**Consultation Response from KC,  
Conservation and Design**

**2021/90800 Hinchliffe Mill, Water Street, Holmbridge, Holmfirth, HD9 2NX**

**Redevelopment and change of use of former mill site to form seven residential units within the mill building and erection of 17 dwellings (within a Conservation Area)**

**Date Responded: 30.03.21    Responding Officer: NG    Responding Ref: CA21**

HOUSE TYPE : UNIT 16

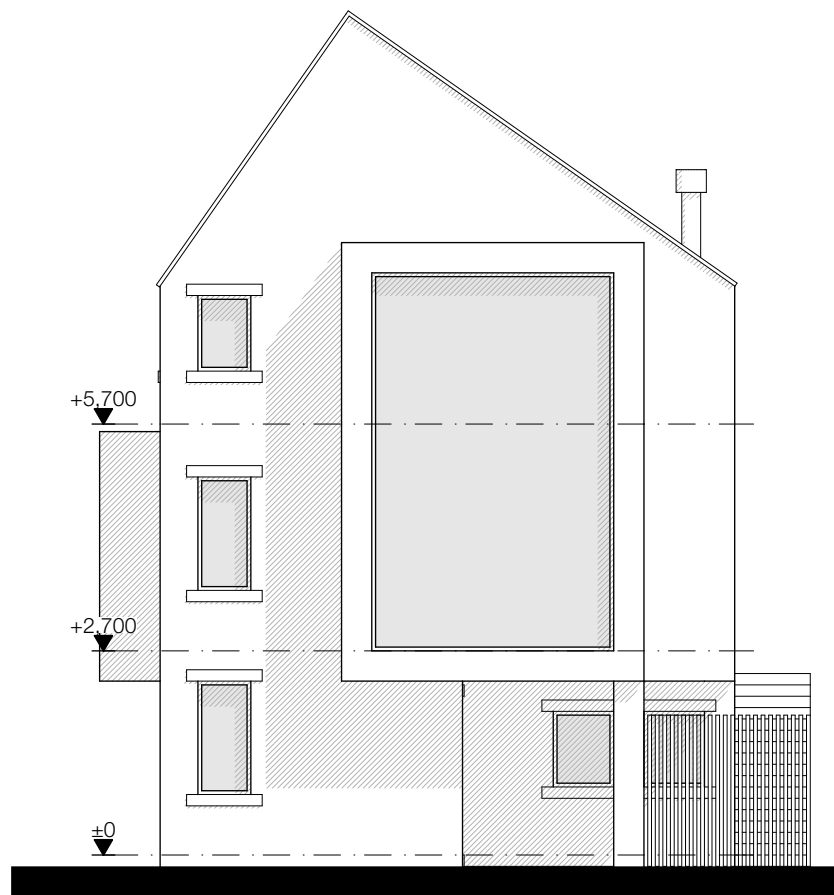
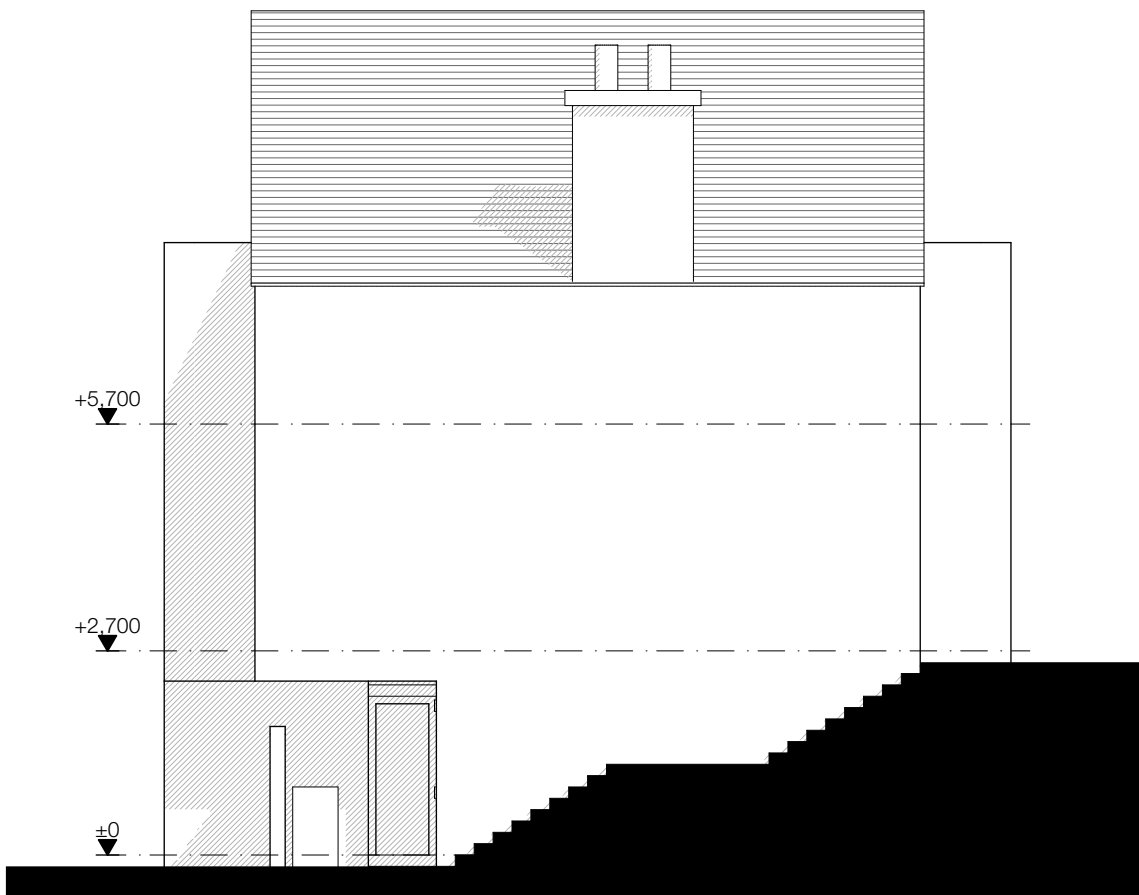
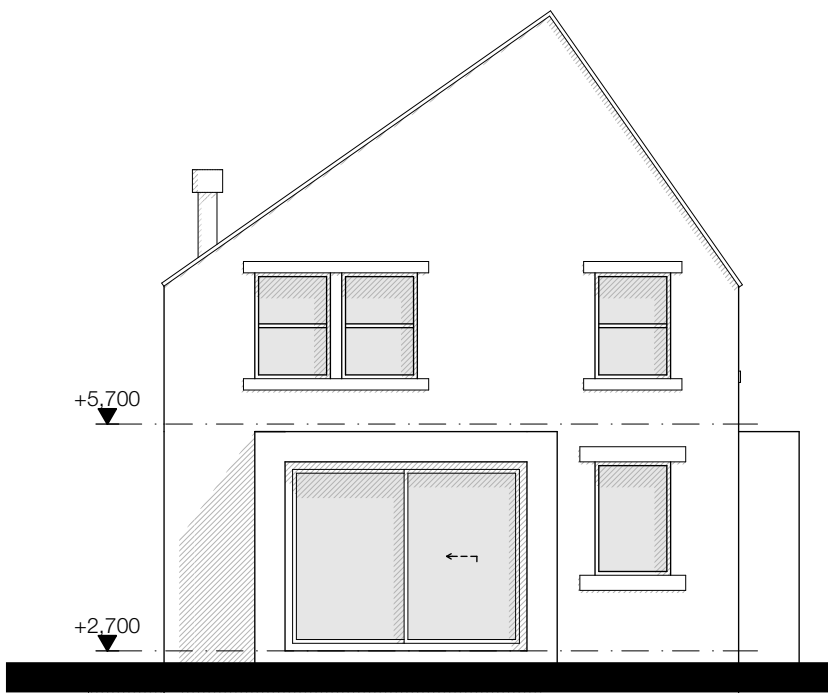
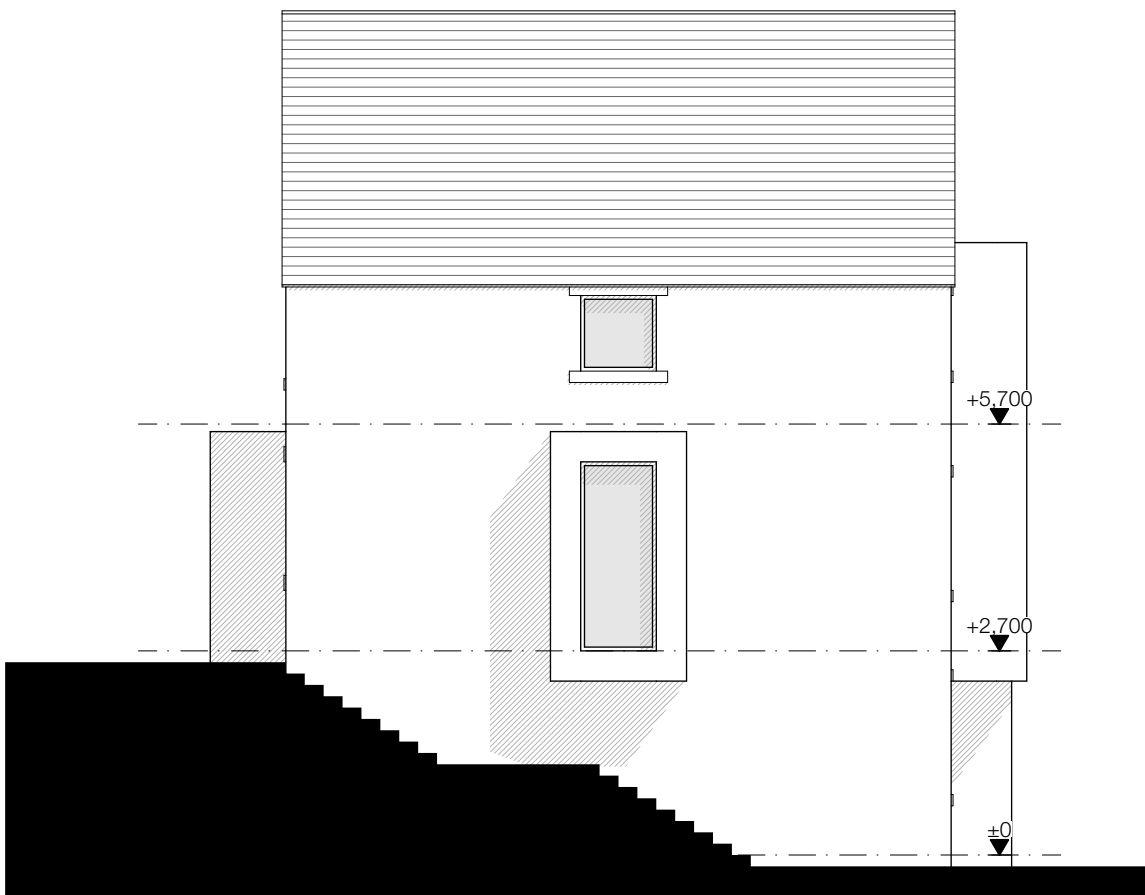
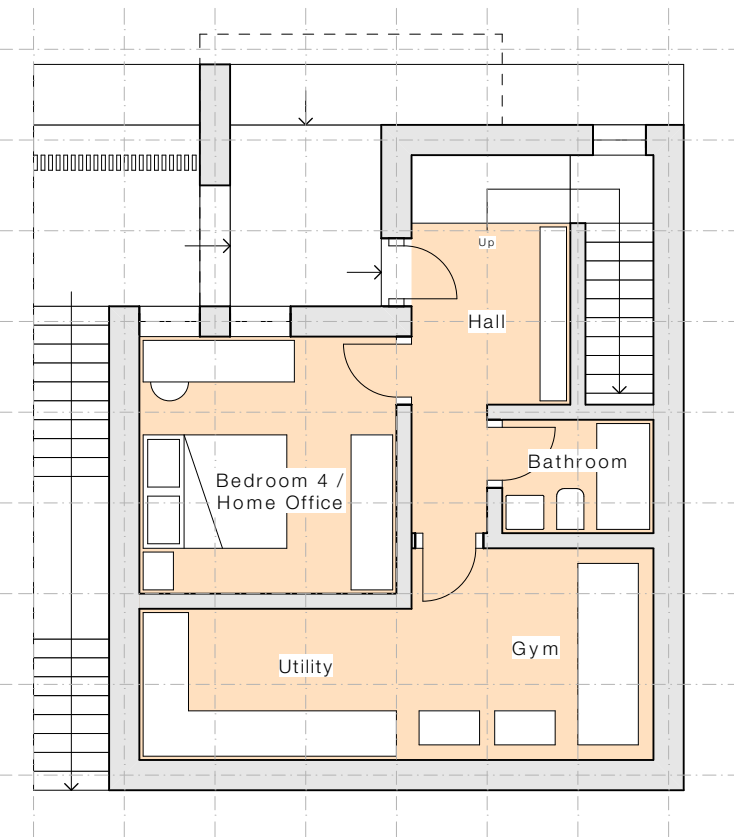
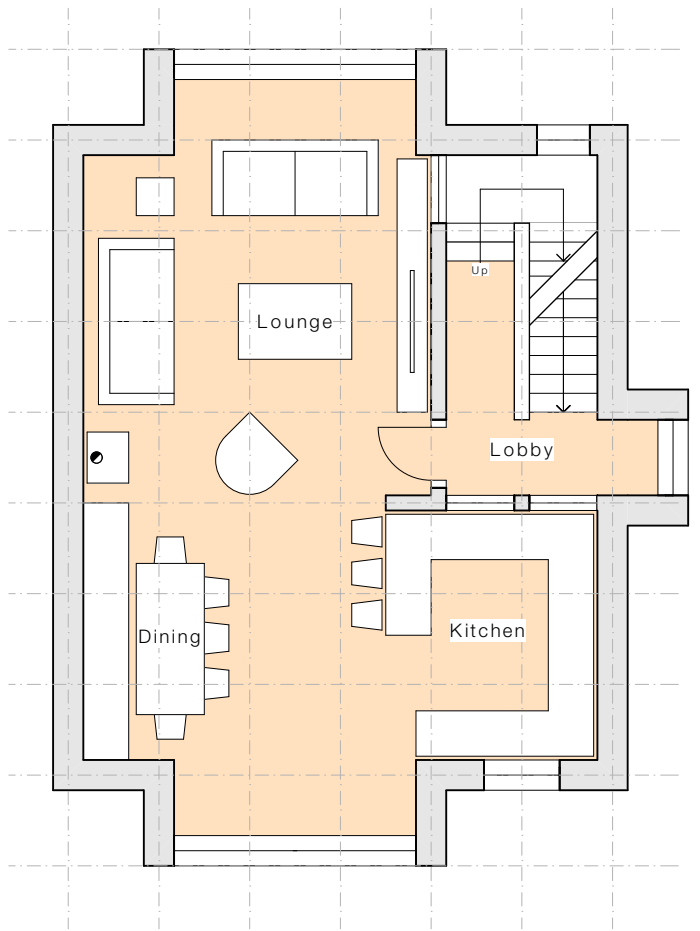
properties would be read as an unduly dominant intrusion into both the setting of the mill and the adjacent countryside. The views across the valley would be dominated by these highly assertive suburban-style villas. The proposed terraced units 11-16 make a token attempt to suggest a bold, north-light roof form of an industrial complex, although this does not reflect the simple architectural form of the demolished ancillary units and is not convincing as an architectural expression of the site's origins.

Job Title Proposed Residential Development, Hinchcliffe Mill, Holmfirth, HD9 2NX	
Client MD One Ltd	Company AD
Status Planning	
Drawing Units 3 - 9 Mill Units	Scale of A1 1:100
Date Dec '20	Drawn / Checked FWG
Drawing No. 3372 (0-) 300	Revision E

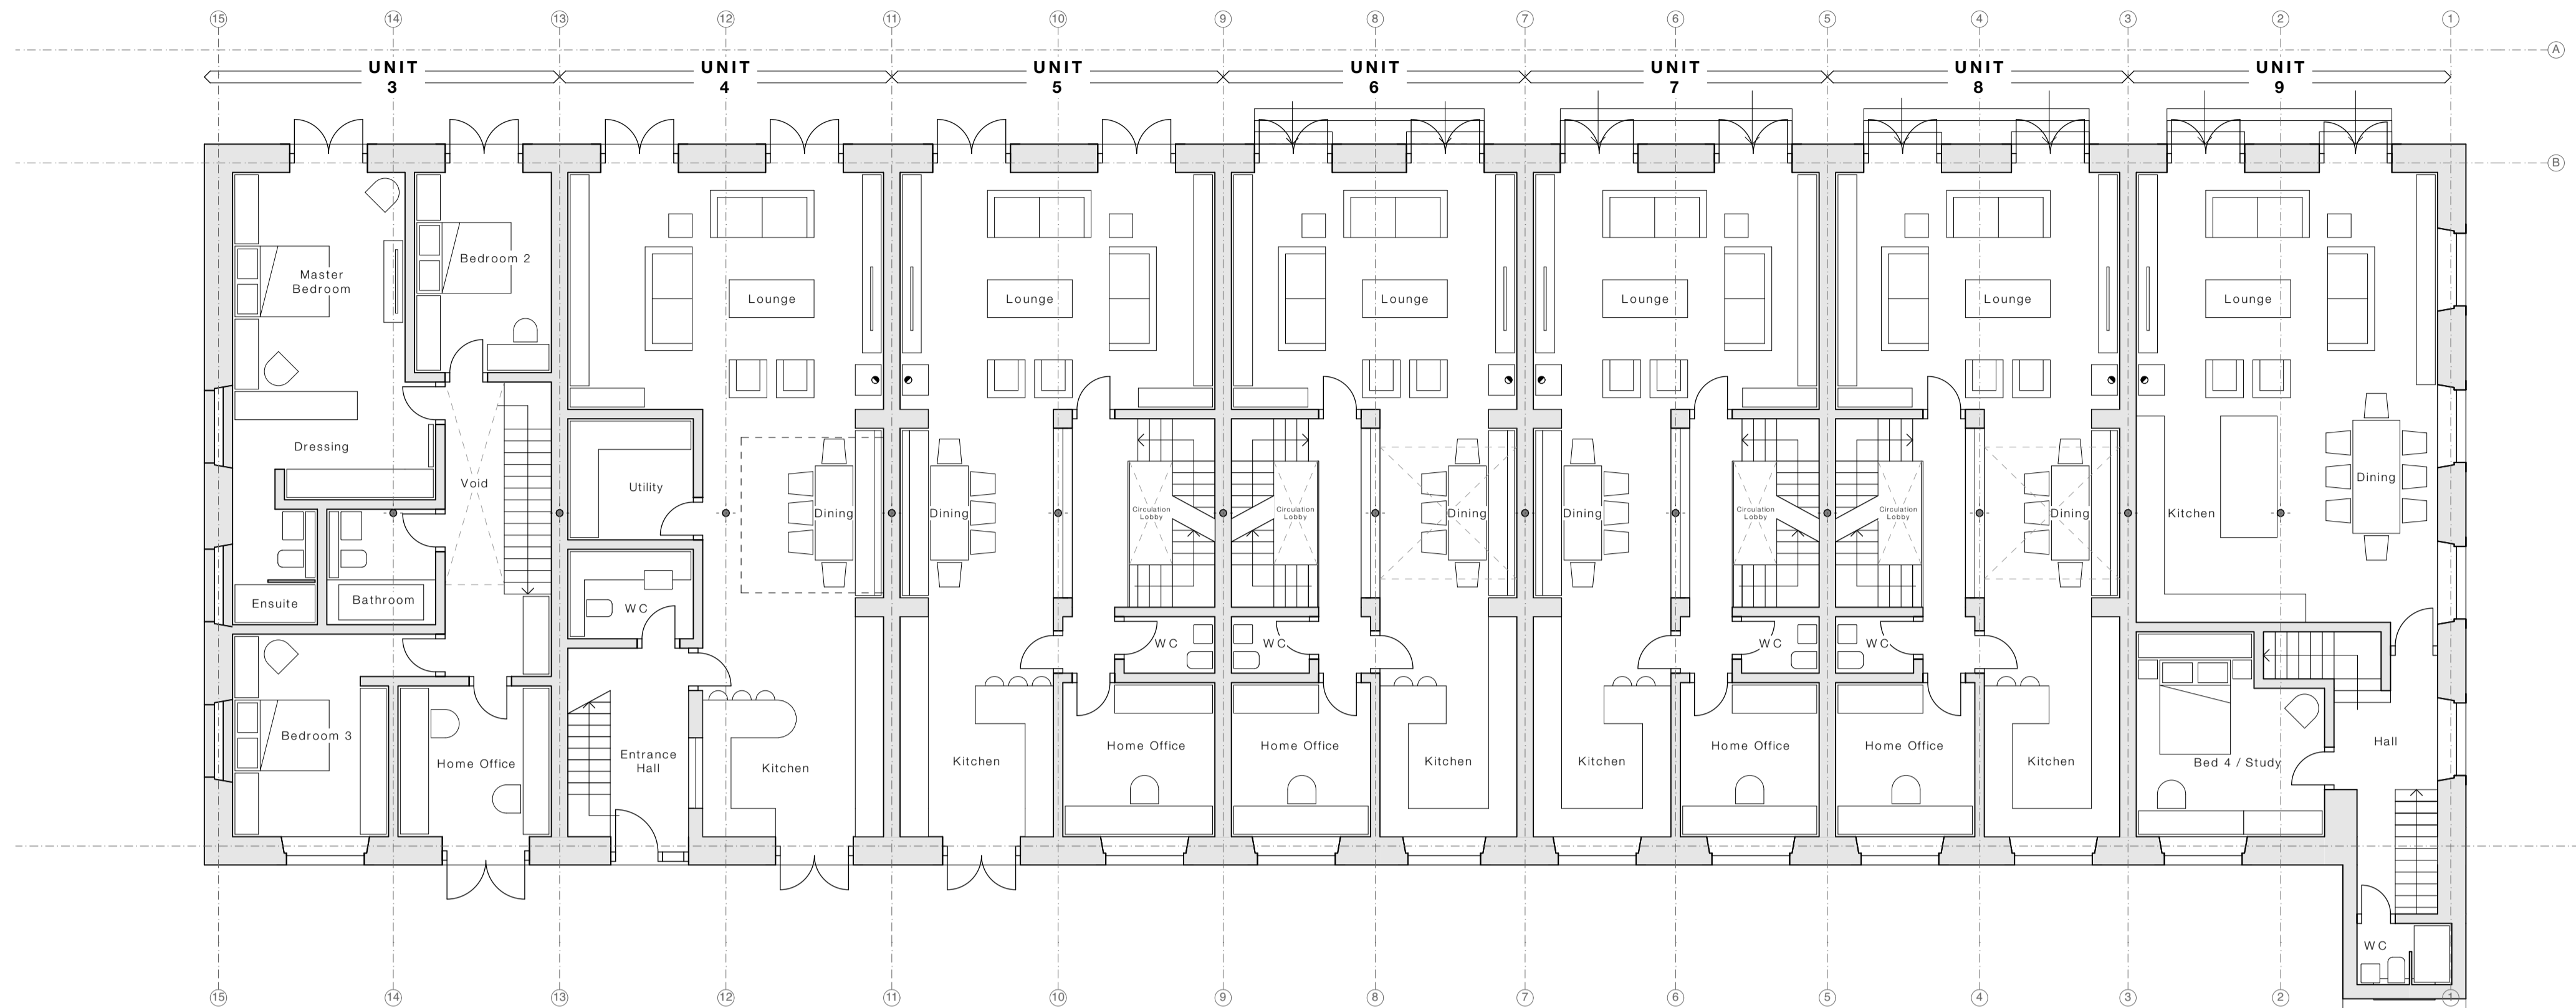
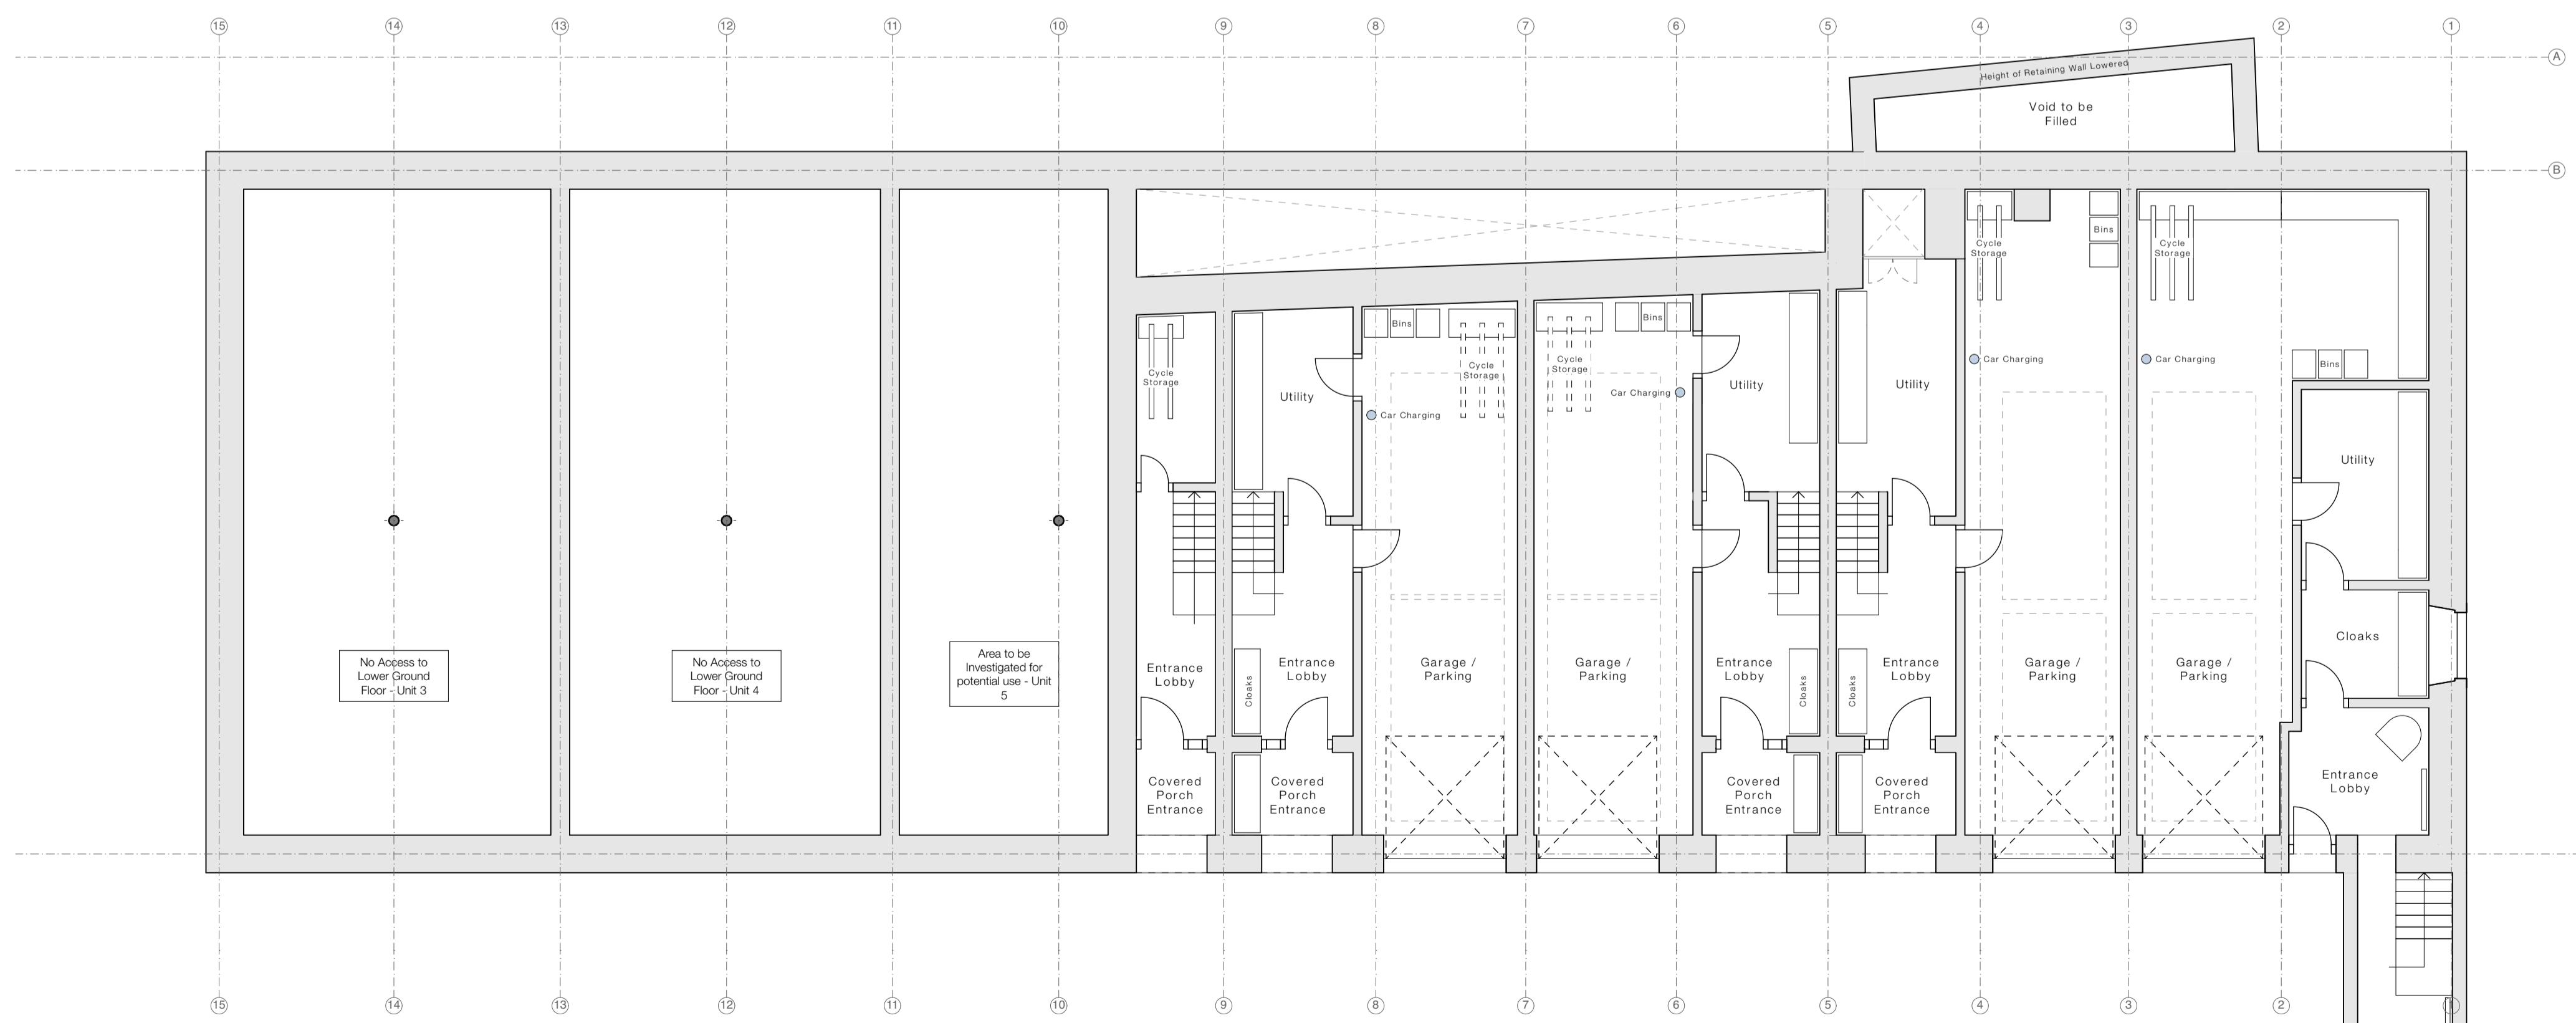
The current application introduces significant changes from the 2010 consented scheme which would result in a greater compromise of all aspects of the former mill complex. The changes to the previously consented scheme include a greater degree of alteration to the surviving mill building. These include an increased number of openings (and loss of original fabric) to accommodate internal garaging, as well as a comprehensive change to the fenestration pattern and elevational changes which further erode the already compromised character of the former industrial building, diminishing its significance and special interest. The interior of the mill remains comprehensively sub-divided in the proposed scheme. The cumulative impact would be a further erosion of the character of the architectural interest of the mill building.
